October 6, 2021

Our File: AVE 866.4

Reference: Updated technical memorandum addressing agency comments on environmental reports for Site 3 of the National Capital Business Park, 4055 Russell Road, Ottawa

TEST HOLE LOCATION PLAN

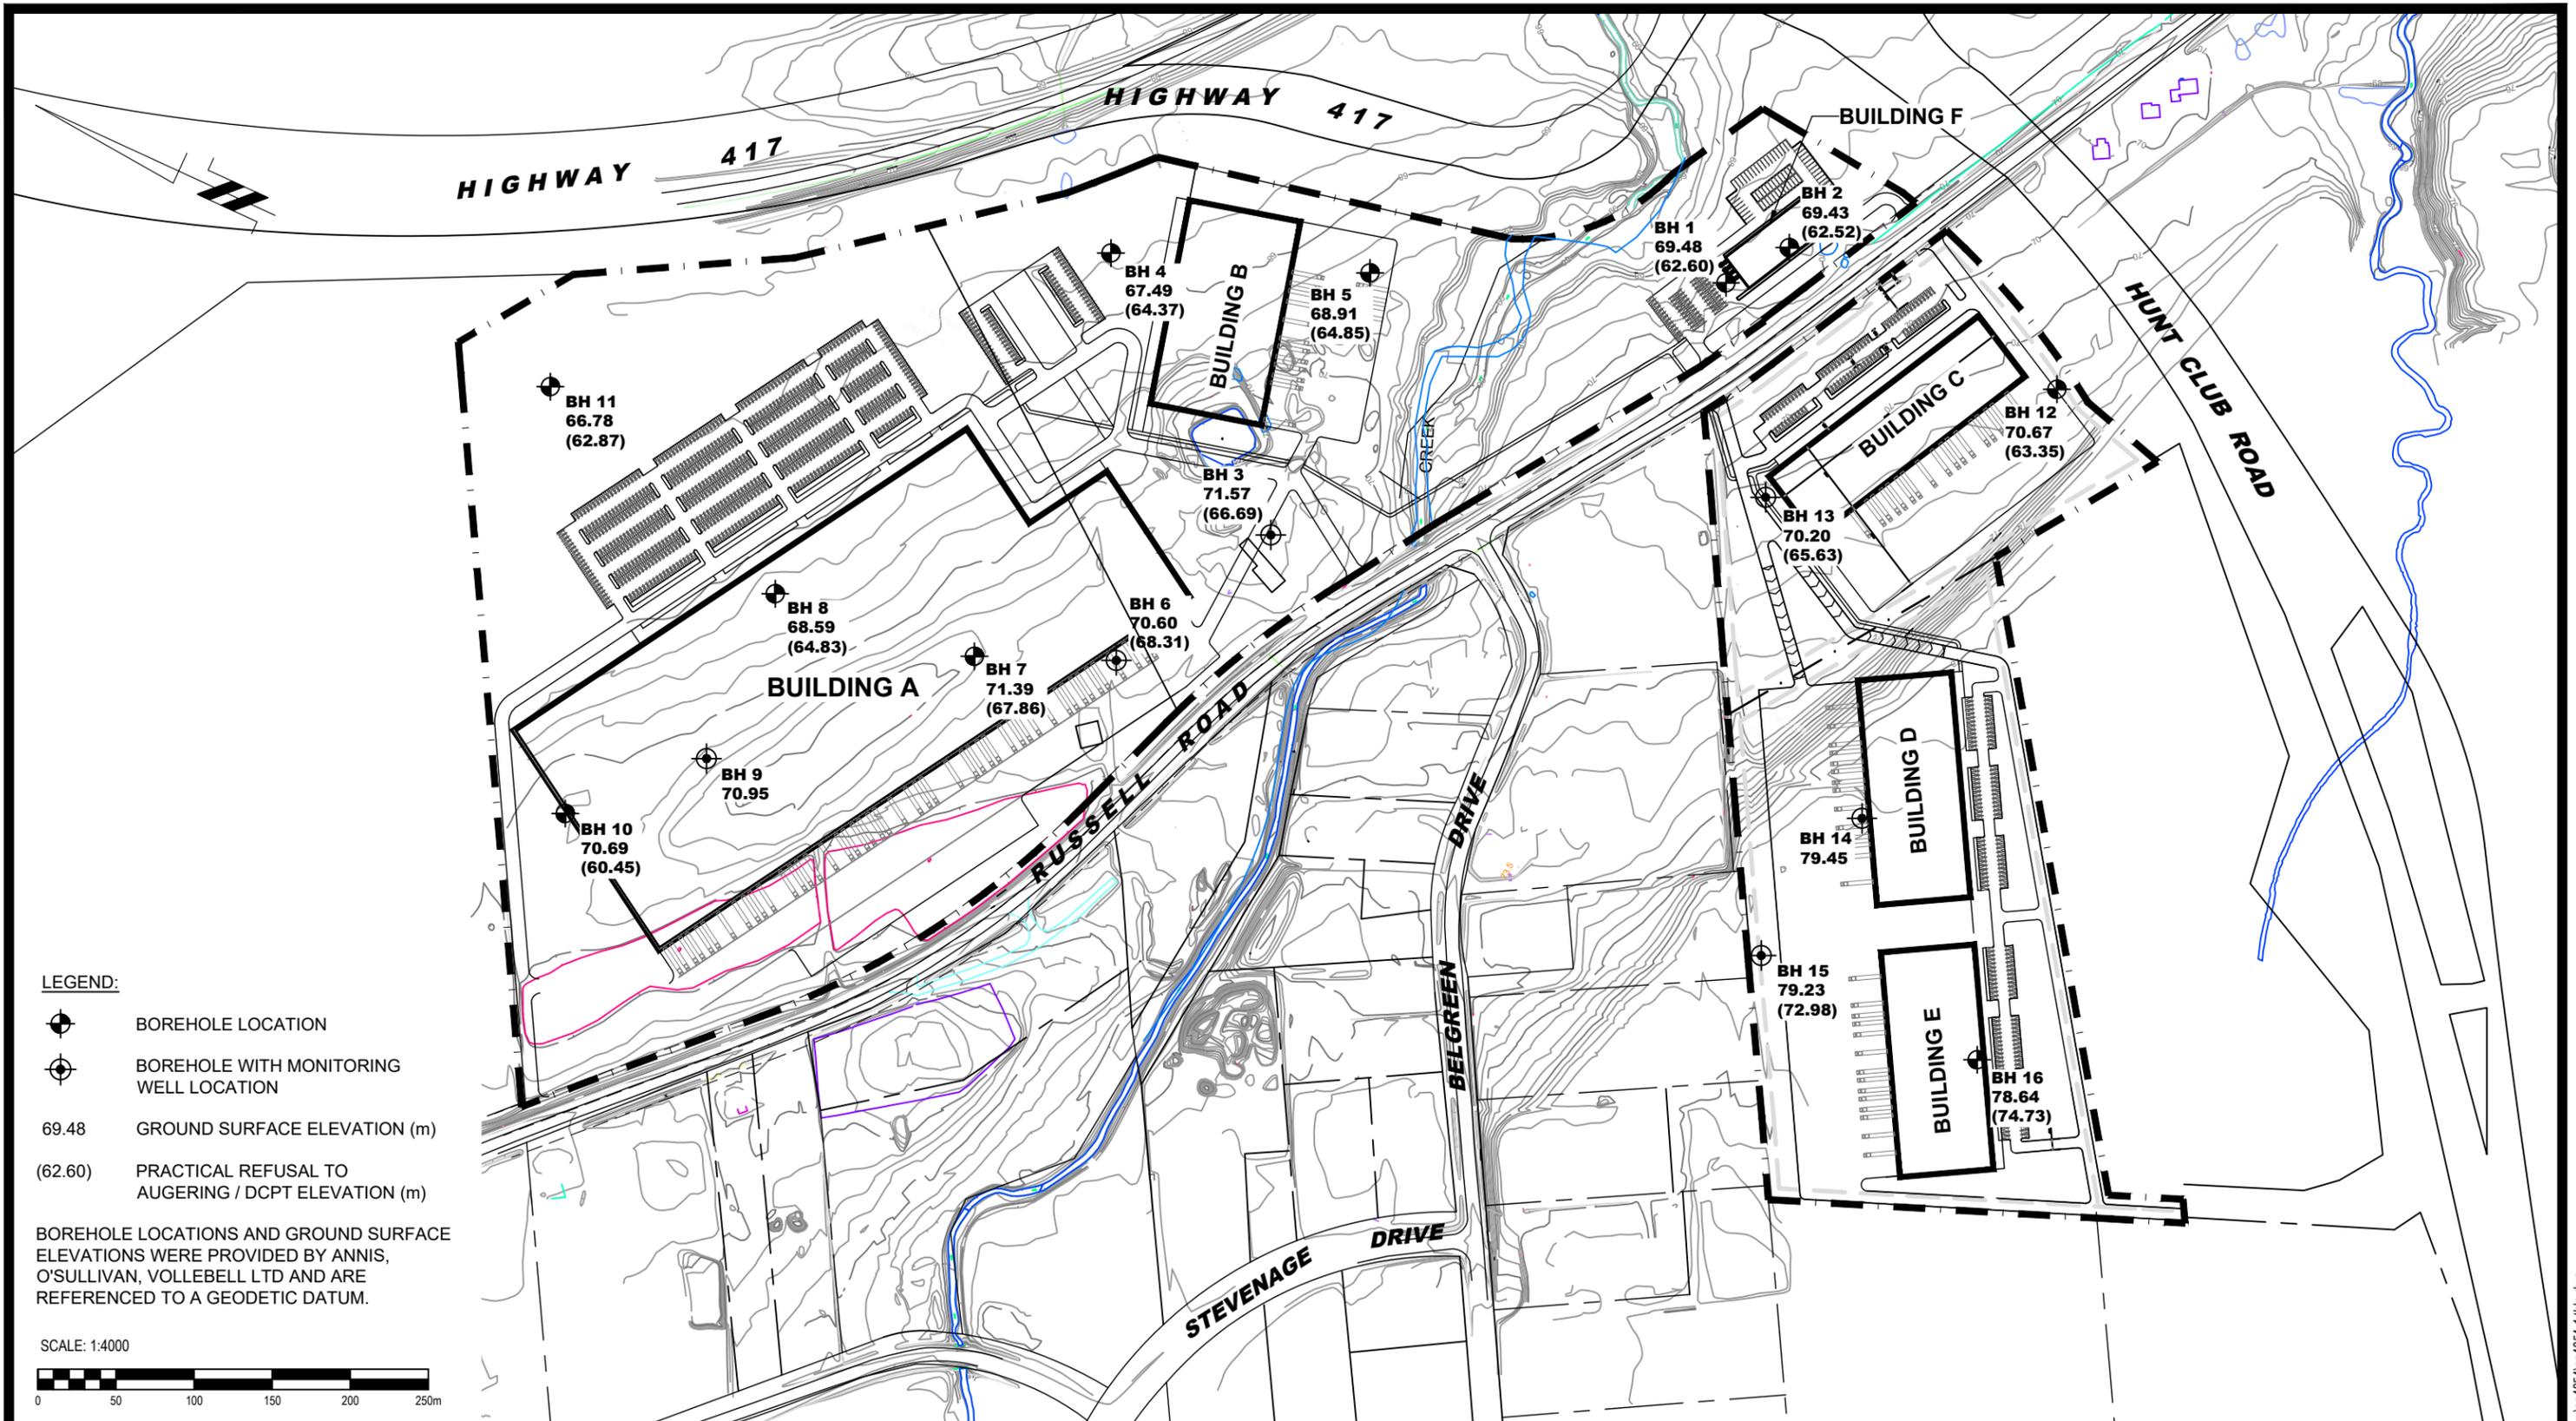
47. Table 3 - soil information should be up-dated to include information obtained on site as part of the geotechnical study and through the EIS if soil augers used.

- Soil information collected through the geotechnical investigation performed by Paterson Group (2020) includes more detail than that collected from soil augers used in Ecological Land

Classification conducted for the EIS. Relevant soil information from Paterson Group (2020) is presented in the bullet point below. Soil information collected by Paterson Group (2020) is representative of soil information presented in the Ecological Land Classification for the NCBP (KAL, 2020a).

- Generally, the soil profile encountered at 11 test hole locations on Site 3 consisted of a 100 to 250 mm layer of topsoil underlain by 0.3 to 3 m of loose to compact brown silty sand. A silty clay deposit was found to be underlying the silty sand for nine out of 11 boreholes on Site 3, extending to depths from 2.1 to 9.5 m. The silty clay generally had an upper crust consisting of a hard to stiff brown silty clay, becoming a stiff to firm grey silty clay at approximate depths of 1.5 to 5 m. A glacial till deposit was generally encountered underlying the silty clay, consisting of a compact to dense grey silty clay with sand, gravel, cobbles, and boulders. Depth to bedrock was estimated to range from 2.3 to 10.3 m. Bedrock in the area consists of shale of the Carlsbad Formation with overburden drift thicknesses between approximately 2 and 10 m depth.

DRAWING PG4854-3 - LIMIT OF HAZARD LANDS

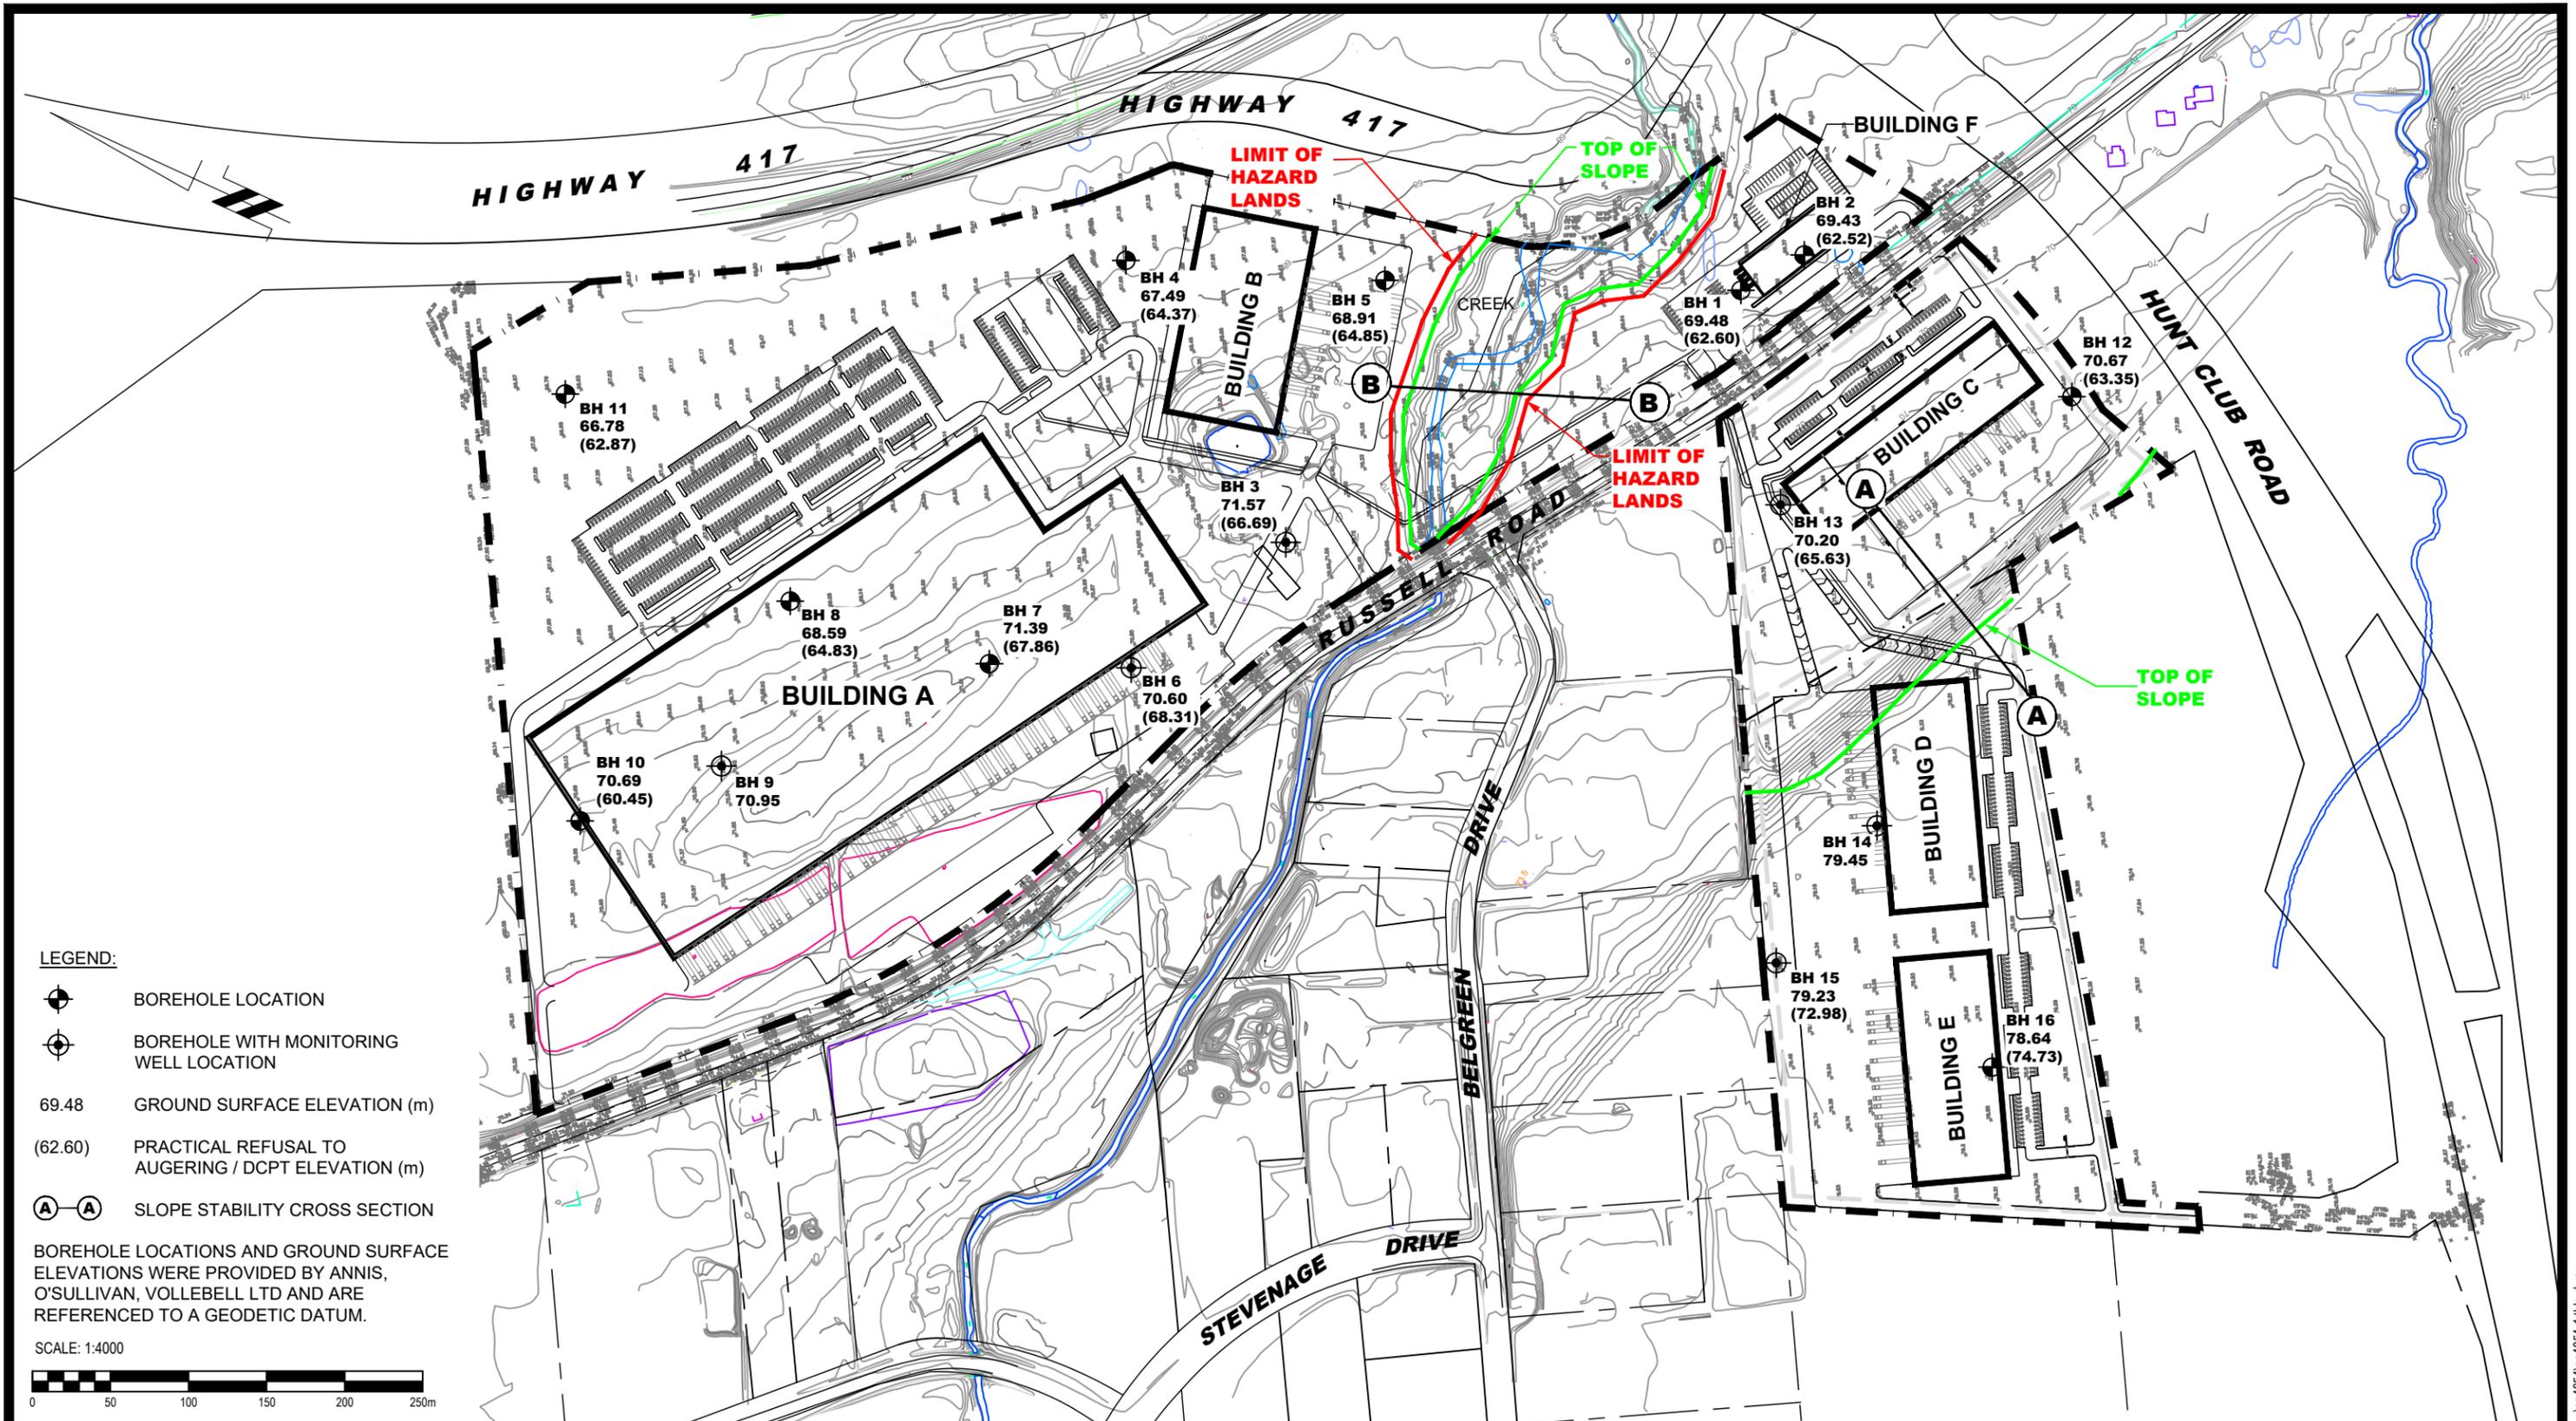
It is not clear on the plans provided what watercourse setback is being provided for Reaches 1 and 2. A site plan clearly identifying the 30 metre setback from the normal highwater mark for Reaches 1 and 2 (as identified in the Kilgour & Associates report) is required. The plan should also include the limit of hazard lands proposed by Paterson Group.

A 30 metre setback is required from the normal high water mark of the watercourse. The proposed outlet should be discussed in the EIS, including the evaluation of its location and potential mitigation measures required.

- Please see Figure 3 below.

- Please see the response to comment 101 from the RVCA above and Figure 3 regarding setbacks.
- Regarding the proposed stormwater outlet into the Mather Award Drain:

- The proposed headwall location is within a relatively shallow grade outside of the hazard limit (Appendix F) which, combined with erosion control measures (such as a rip-rap spillway at the outfall), should prevent scouring in the drain by discharged water. The stormwater management plan also incorporates retention basins on the site which will also aid in the reduction of flows (Appendix F).
